For and on behalf of
BAE Systems
Interested Party Reference No.
20053944

DEADLINE 3 – COMMENTS ON APPLICANT'S SUBMISSIONS MADE AT DEADLINE 2

Morgan and Morecambe Offshore Wind Farms Transmission Assets DCO Examination

Figure 1.6: Biodiversity benefit area at Lea Marsh Fields

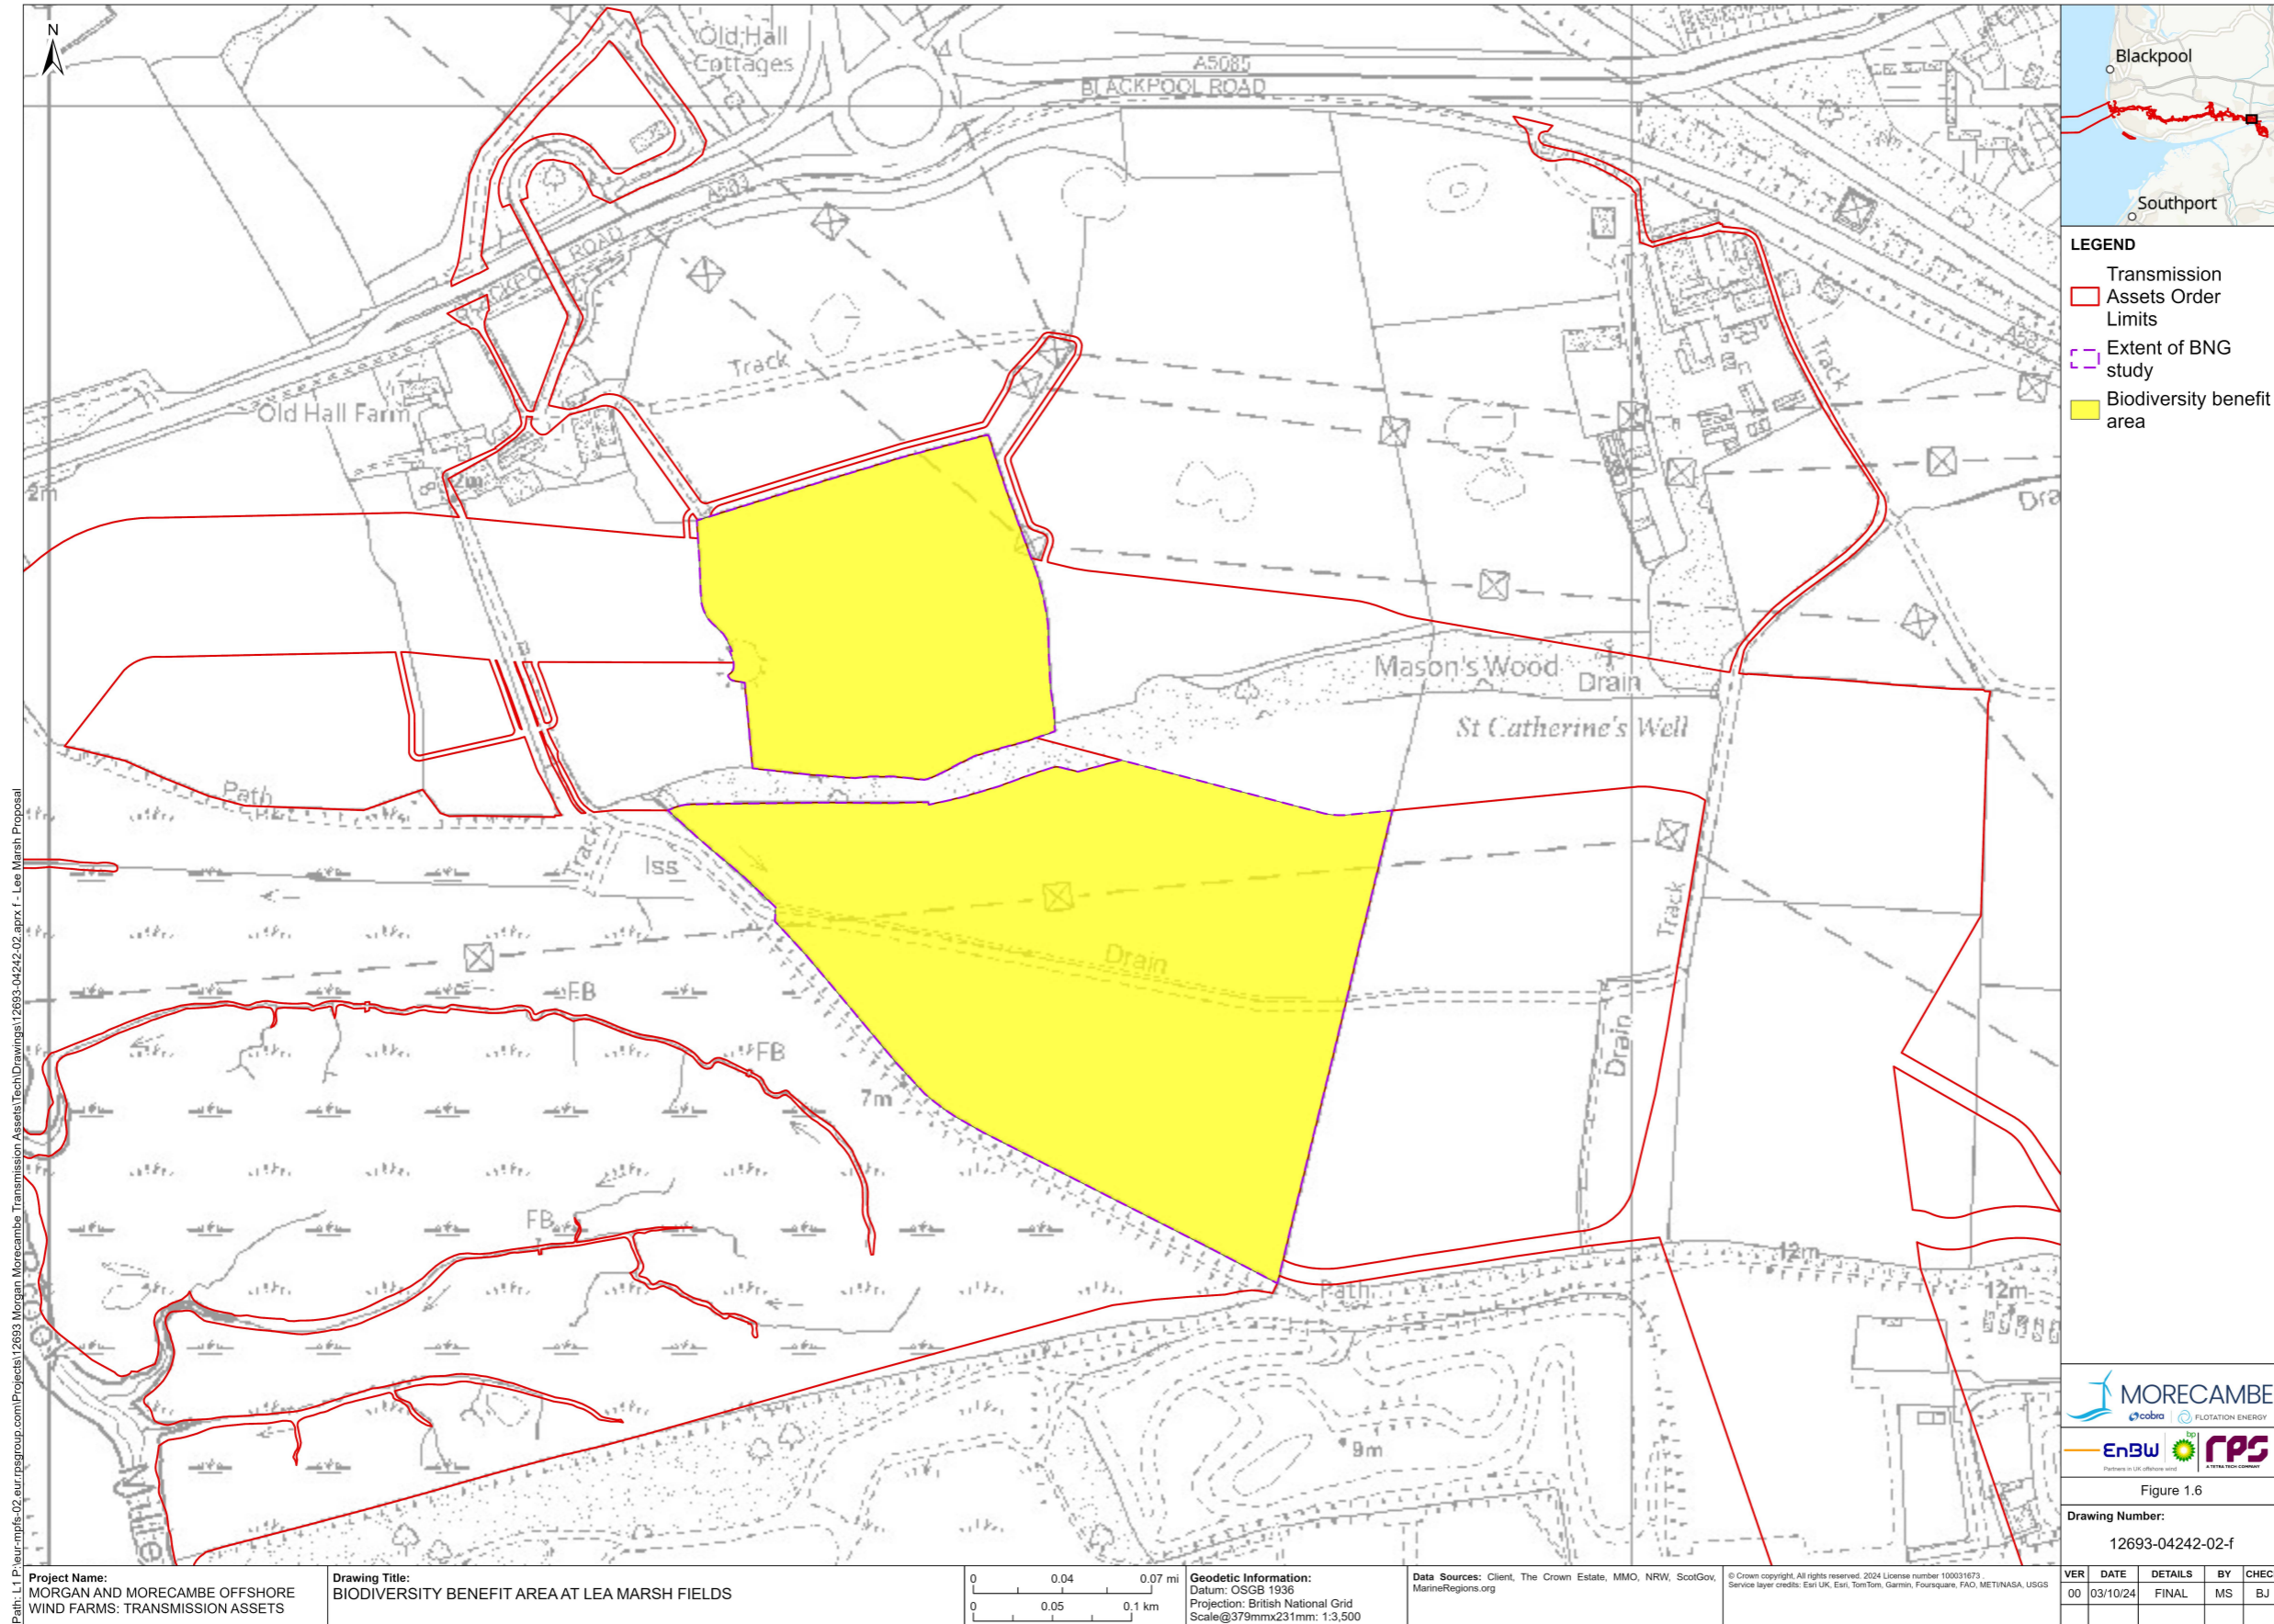
6.1 In a similar manner to the oEMP, the Onshore Biodiversity Benefit Statement has been updated to include further detail, albeit of a high level, on the design of the biodiversity benefit site at Lea Marsh Fields. BAE Systems' comments in relation to the oEMP (see paragraphs 5.1 and 5.2 above) also apply to the Onshore Biodiversity Benefit Statement.
